Recommendation Report for Planning Permission for Works or Extension to a Dwelling

REF NO: BE/179/21/HH

LOCATION: 10 Brazwick Avenue
Bersted
PO21 5DZ

PROPOSAL: Side and rear single storey extension.

Drawing: Existing and Proposed Roof Plans
Scale: 1:100 @ A3
Date: 06/12/2021

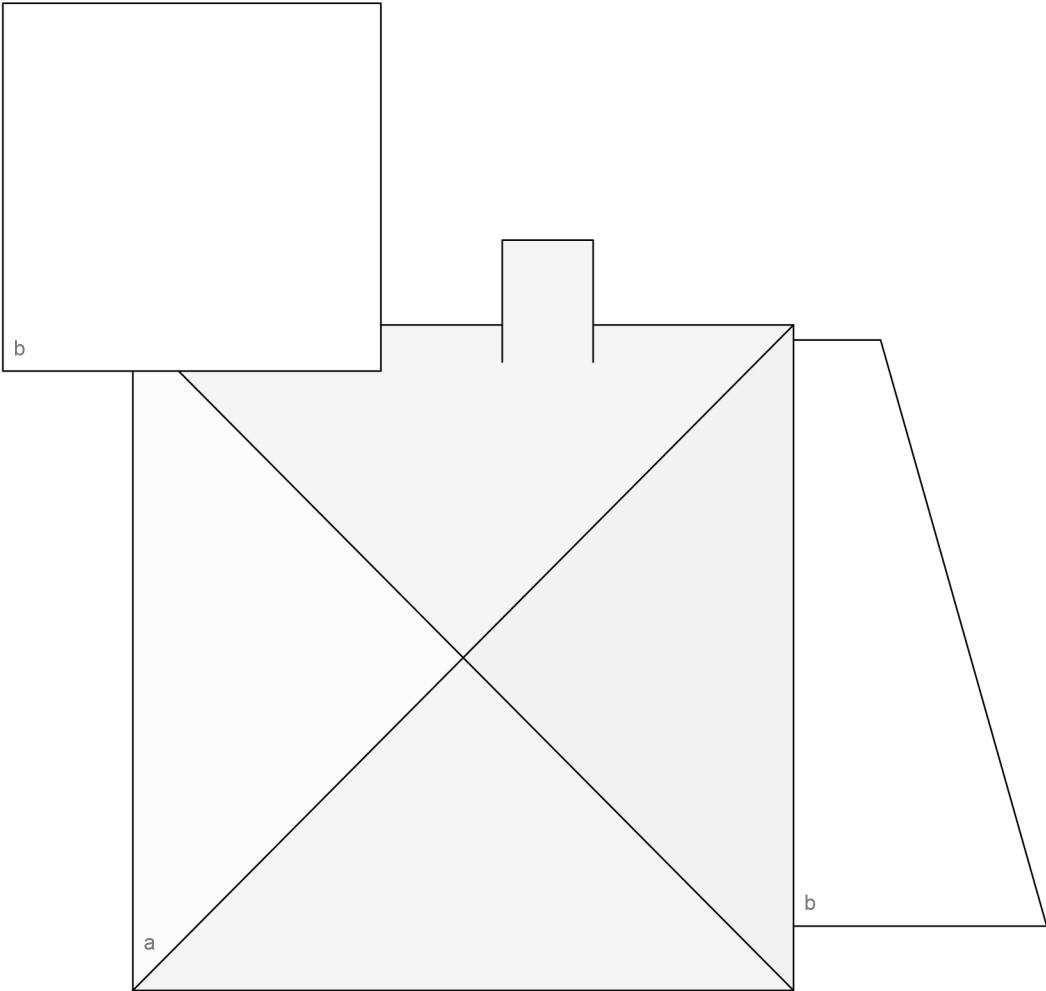
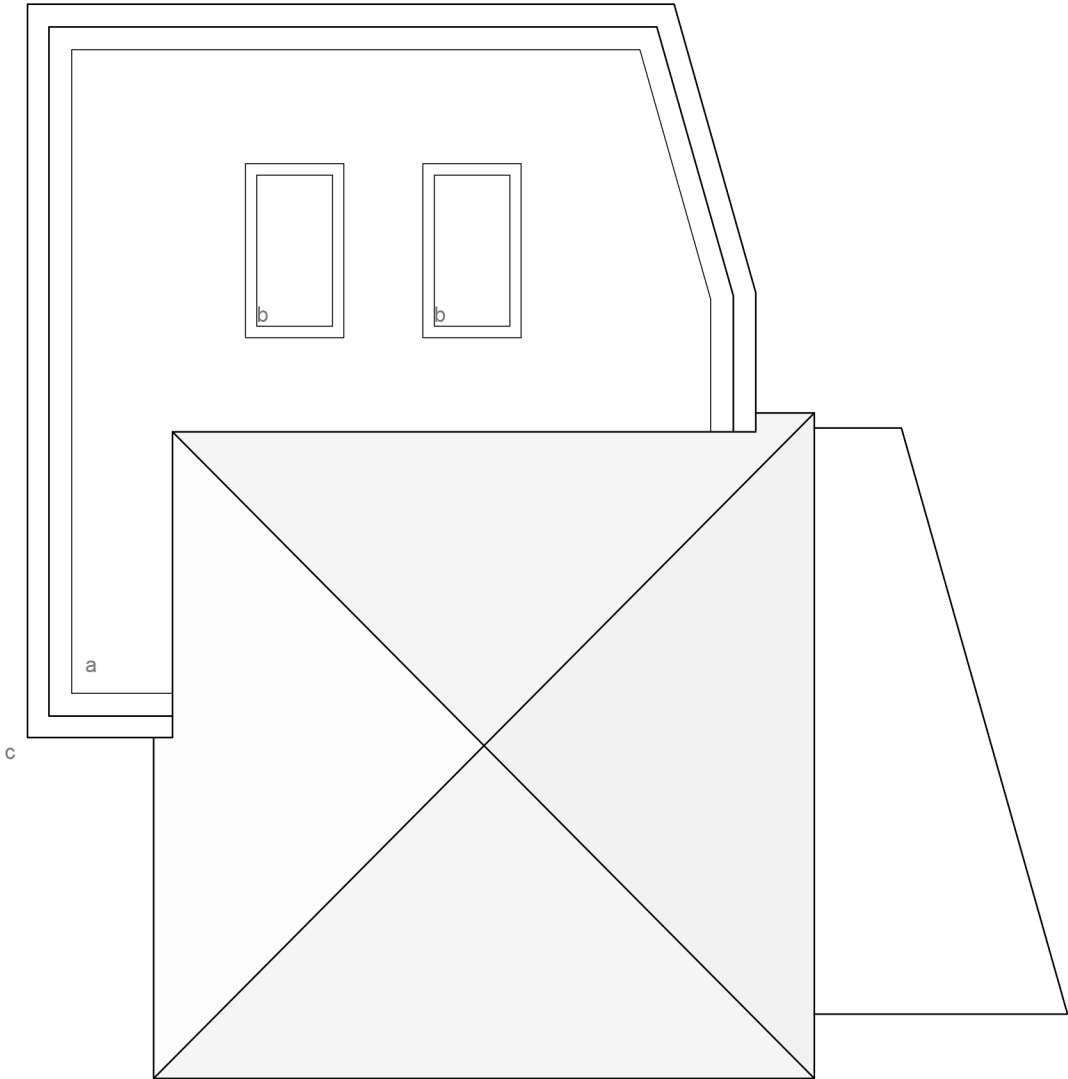
The extensions feature a single window to the front; a set of bi-fold doors, a single door and a window to the rear; and two skylights in the centre of the roof to the rear. These features do not overlook, overshadow or overbear any neighbouring properties and will not be unduly harmful to residential amenity.

Drawing: Existing and Proposed Floor Plans
Scale: 1:100 @ A3
Date: 06/12/2021

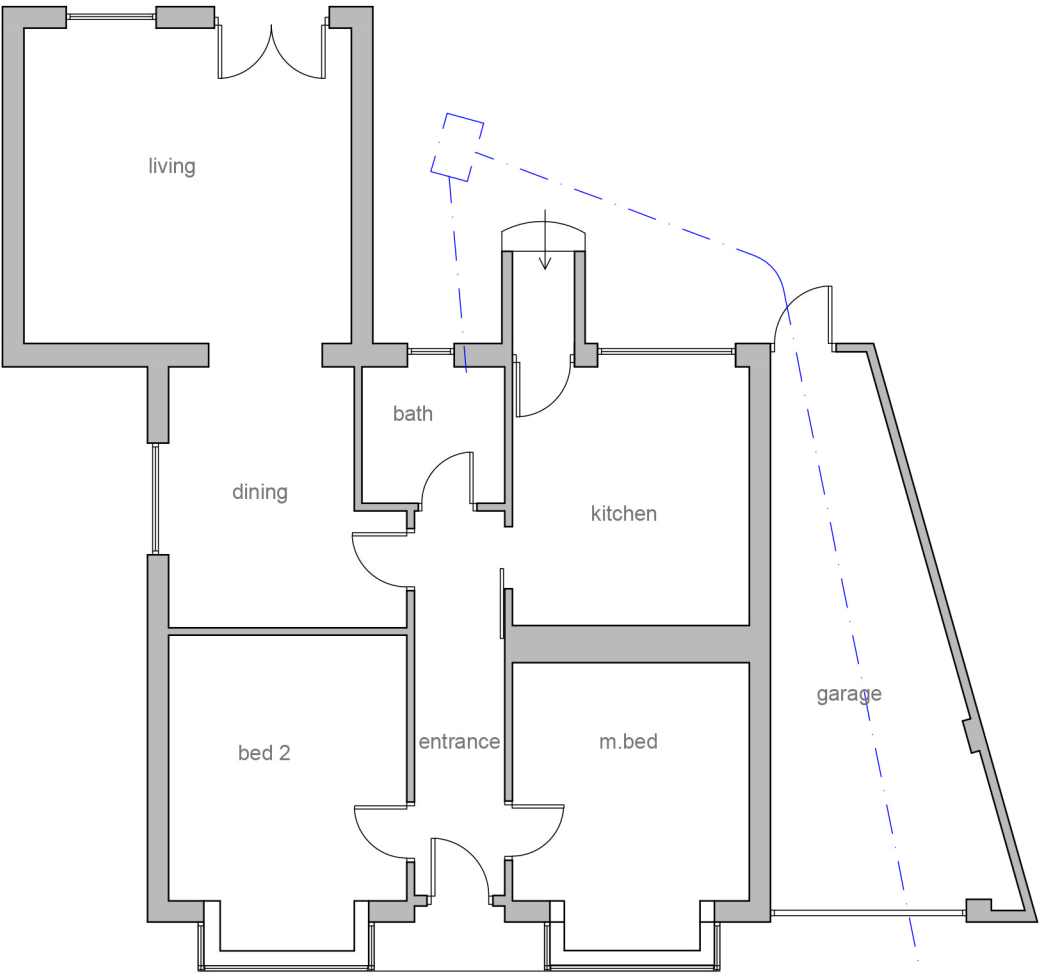
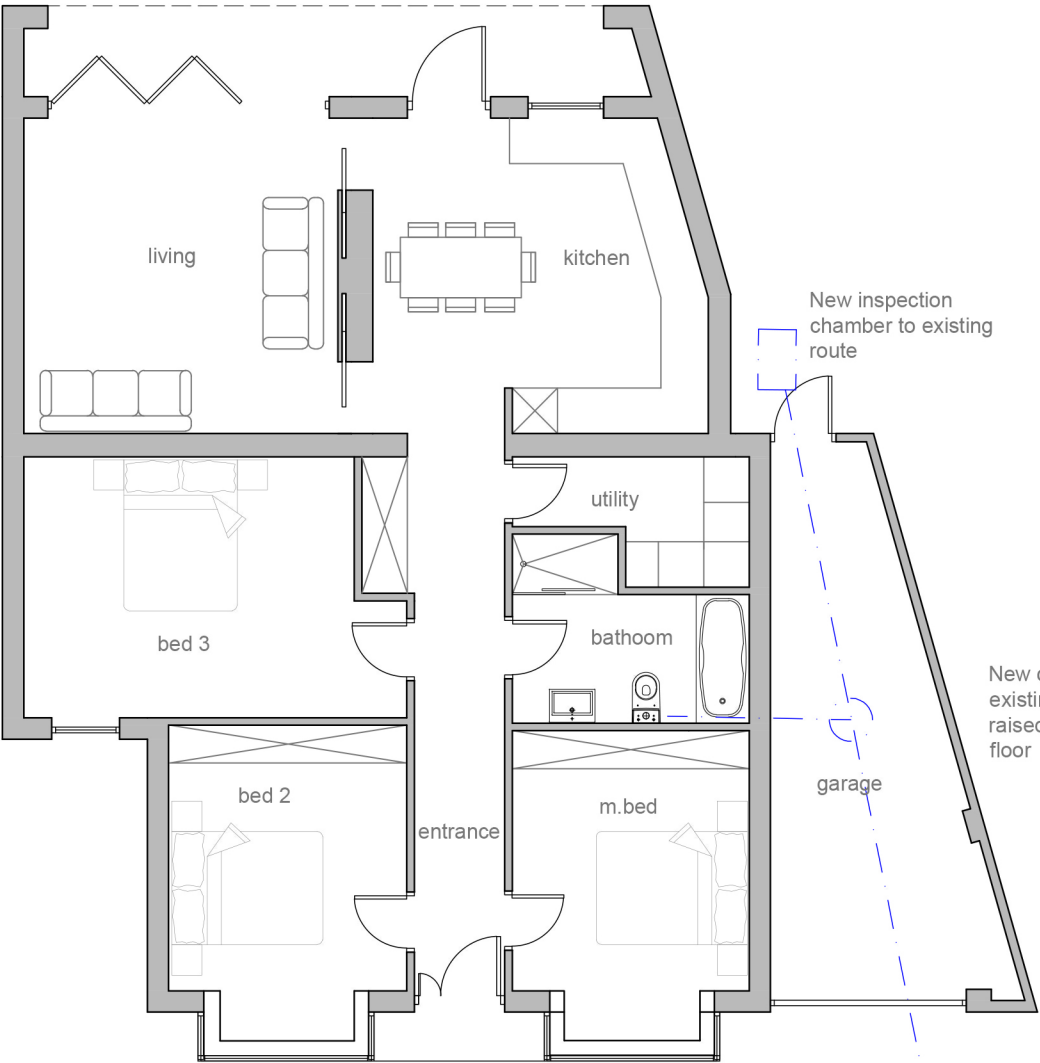
The extensions will be single storey and wrap around the dwelling, connecting to the sides of an existing rear extension (BE/67/88). The side extension will have a width of 3.75m and depth of 1.92m; the rear will have a maximum width of 9.65m and depth of 5.65m. Both will have flat roofs, following a similar style and design as the existing extension and garage. This differs to the main dwelling which features a hipped roof, but is not considered to be unduly harmful to the visual appearance of the property, and will integrate well with the existing extension. Being towards the rear of the property, the side extension has limited impact on the front elevation and retains a distance of 10.16m from the front boundary, making its visibility limited from the street scene. This visibility is additionally restricted by the boundary line to the south / south west of the property, which features a row of hedges that block views of the property. This reduces the impact of the proposal and as a result, will not cause any disruption to the composition or rhythm of the street.

There is a potential issue with the scale and overall floorspace of the proposal. Part M of the Arun Design Guide states that extensions of over 50% of existing floorspace are unlikely to be considered acceptable. The floorspace appears quite large in comparison to the existing; this may be accentuated however by the floorspace provided by the existing extension, which is connected to the proposed to establish a larger space. When measured, the new floorspace provided by the proposed extension is only around 35m² and does not exceed 50% of the existing, making the scale of the proposal acceptable. This is in accord with Part M.

Drawing: Proposed Elevations
Scale: 1:100 @ A3
Date: 06/12/2021

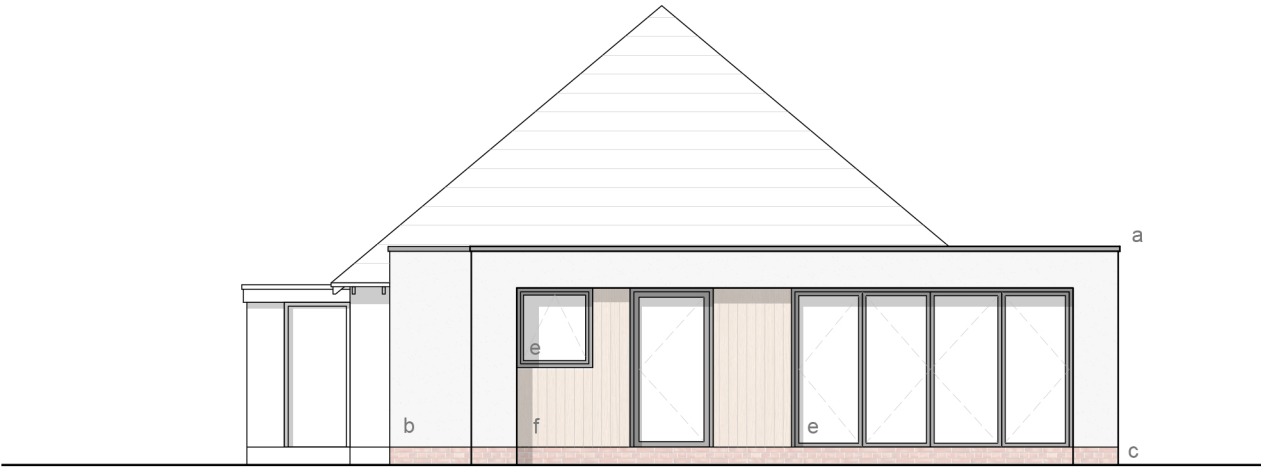
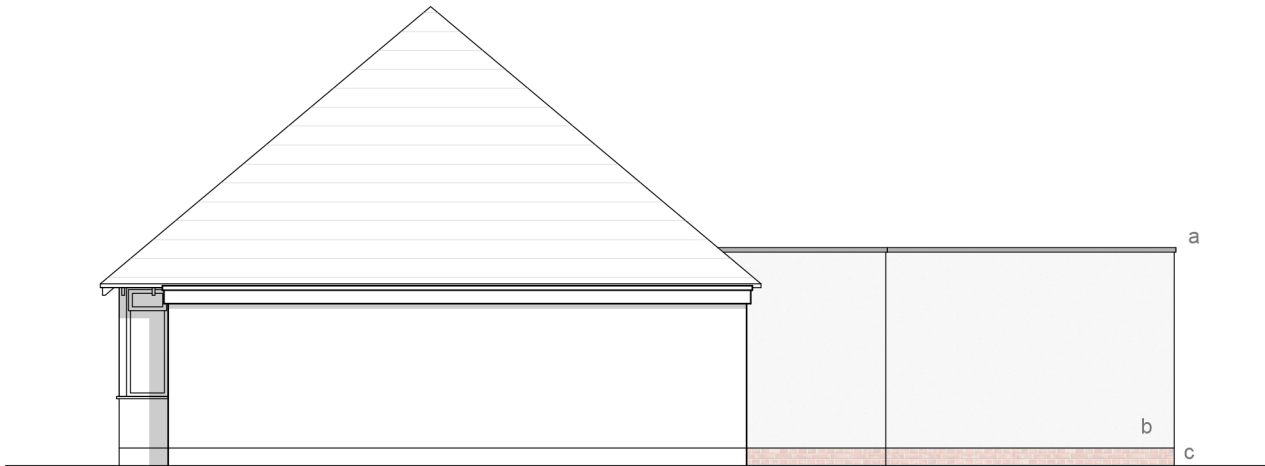
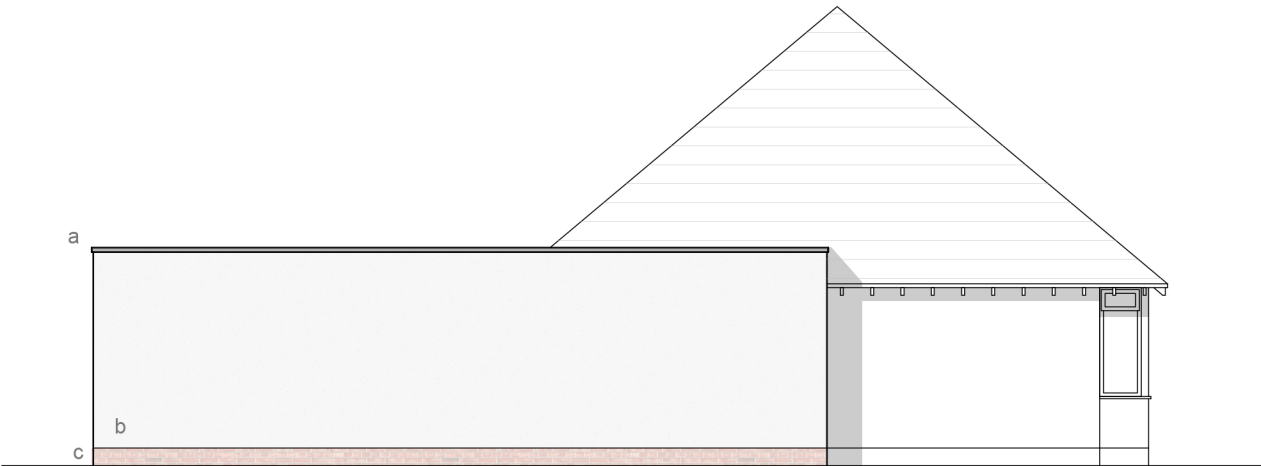
The proposal does not appear overly subservient to the host dwelling but is well integrated with the existing extension and garage. The materials used will match the existing in parts, incorporating new materials in places such as the roof. This is not considered unduly harmful and will have minimal intrusion on the visual appearance and character of the building.

The proposal will have a flat roof and be single storey with a height of 2.87m, retaining the height of the existing extension. It will retain a minimum distance of 0.87m from the south west, 16.07m from the north west and 1.81m from the north east boundaries. This is in accord with D DM4. The use of the 45 and 60 degree rule is encouraged by the Arun Design Guide. This rule is met for the neighbours at No.12. However, the line taken from the window of No.8 is conflicted by the development, meaning the proposal does not comply with these rules. Despite this, given the proposals height and sufficient distance from the window of No.8, the extension is not considered to result in adverse overshadowing or overbearing and will have minimal impact on residential amenity.
